# BRADLEY POINT FILING NO. 1- DRY SUBDIVISION

## LANDSCAPE PLAN

LANDSCAPE PLAN  
SHEET 02 OF 04

PPR243

BRADLEY POINT FILING NO. 1- DRY SUBDIVISION LANDSCAPE PLAN

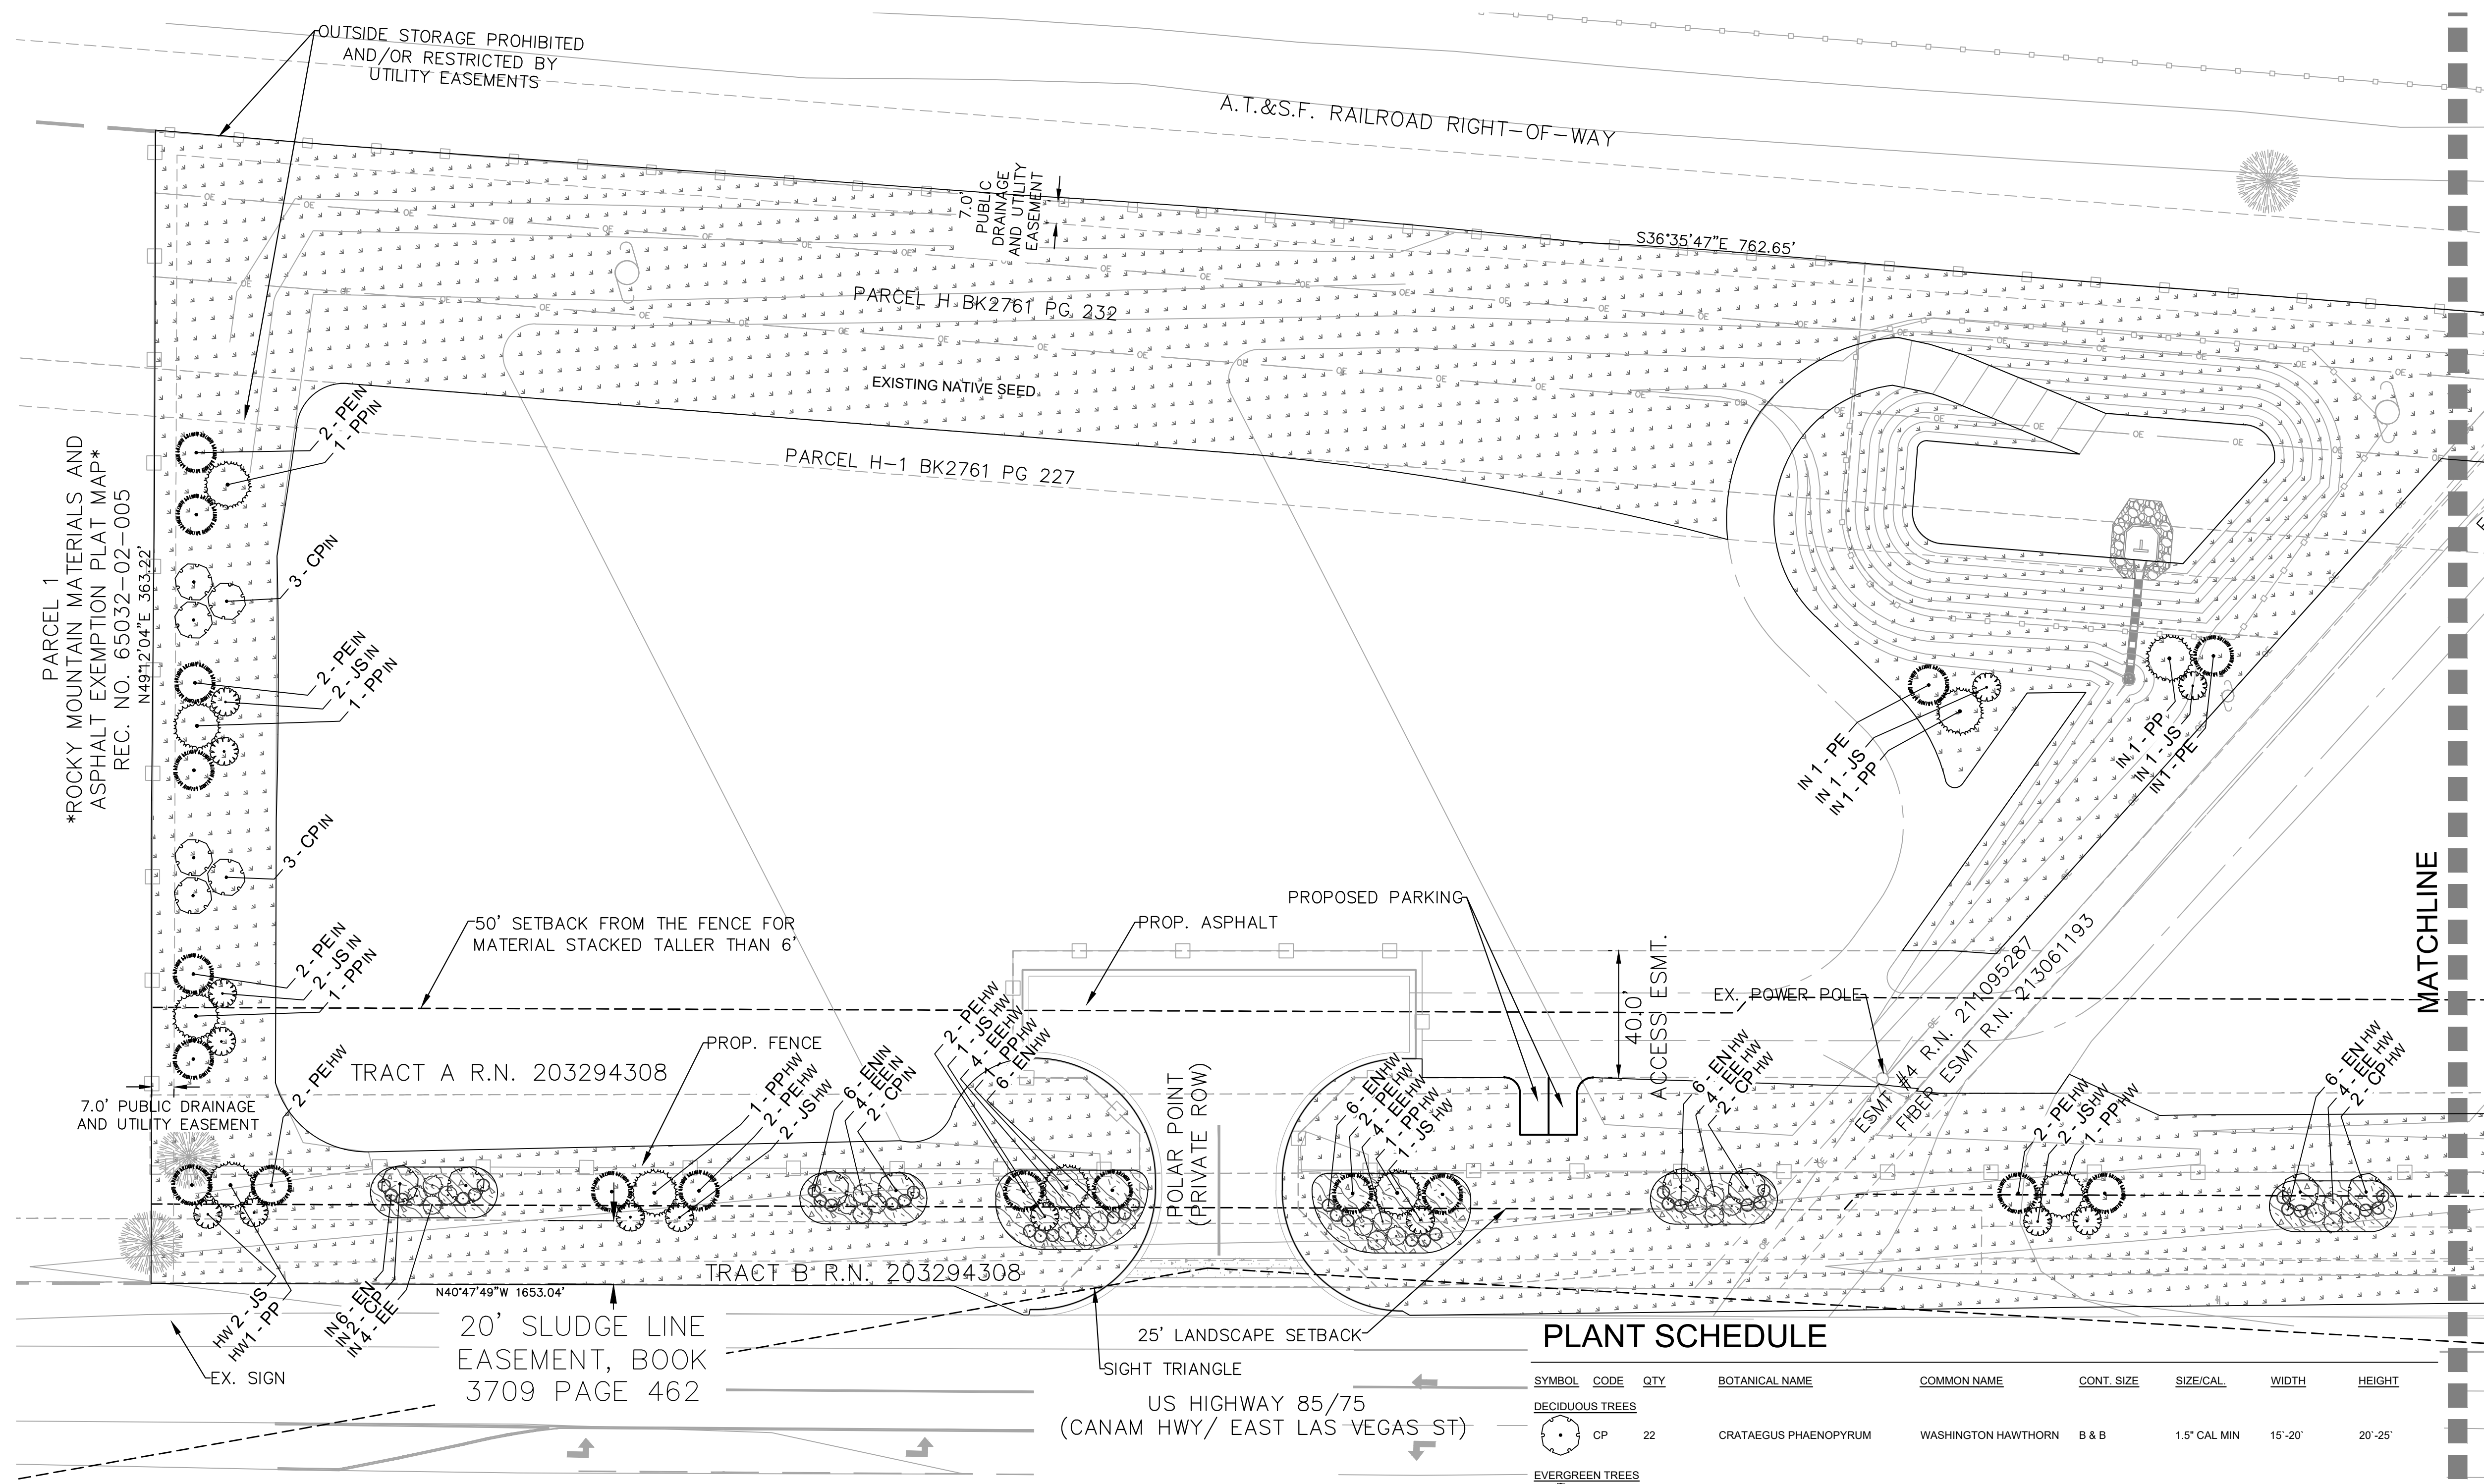
Include a vicinity map and an aerial image of the entire property. This plan only shows a small portion of the property and does not depict any internal landscaping.

Include the location and dimensions of property lines, right-of-way and all existing and proposed easements, and classification of all existing and proposed internal and adjacent roadways(s).

Depict the outlines of all structures, parking areas, outside storage areas, loading areas, and refuse collection area(s) in relation to the landscaping.

No internal landscaping has been depicted. Per LDC Sec. 6.2.2.E, 5% of the site (minus the buffer area) shall be dedicated to internal landscaping.

If the application includes a request for approval of an alternative landscape plan, the landscape plan shall include a statement requesting approval of the alternative design and justification for the request unless otherwise provided for in the letter of intent.

I recommend beefing up the roadway buffer to justify not incorporating any internal landscaping.

What is the depth of the landscape buffer?

Please include the required number of trees in addition to the proposed.

Landscape Plan is missing page 1. Please re-upload with missing pages for next review.
